From: Janice Chapman
Sent: 19 April 2011 16:24
To: 'Matthew C Birch'
Subject: RE: M1/11/ Resubmission

DRAWING: 10/63/4 REVISION:

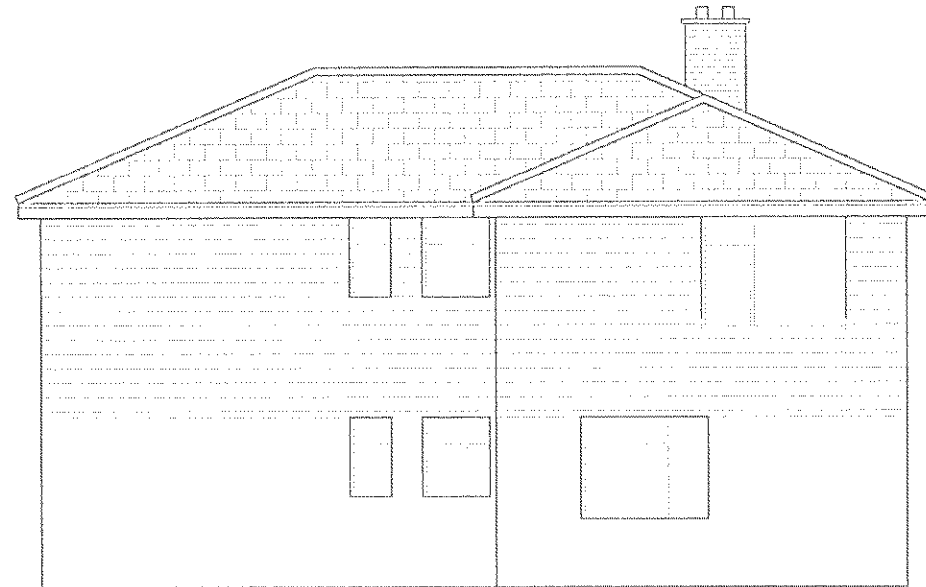
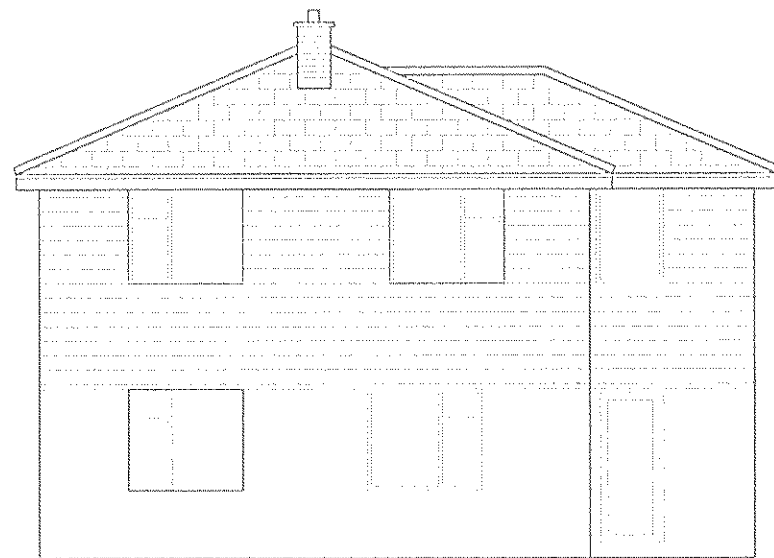
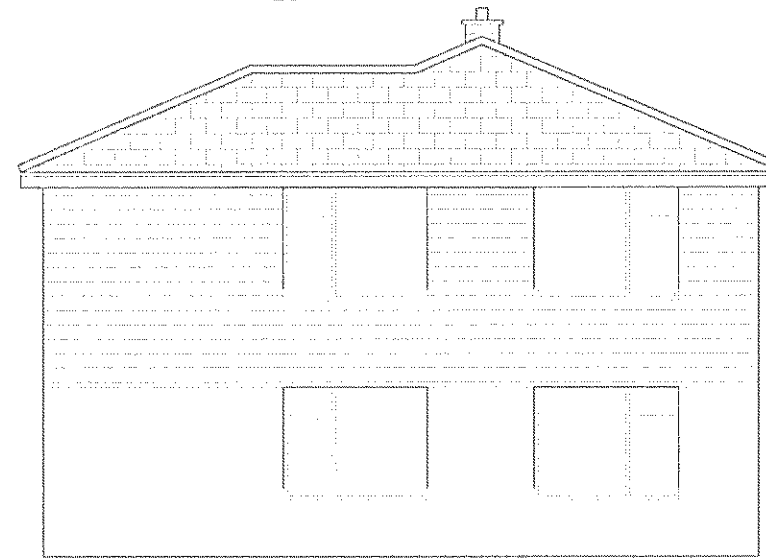
I am in receipt of your amended elevations. I have discussed the drawings with my team leader Mr Parsons and we are both of the opinion that the dormers are too large and appear out of character with the existing dwelling. It would be more appropriate to have smaller dormers and scale down the accommodation at first floor. If you were to submit an application it would be likely to be refused as the size and scale of the dormers would fail to improve the visual amenities of the street scene.
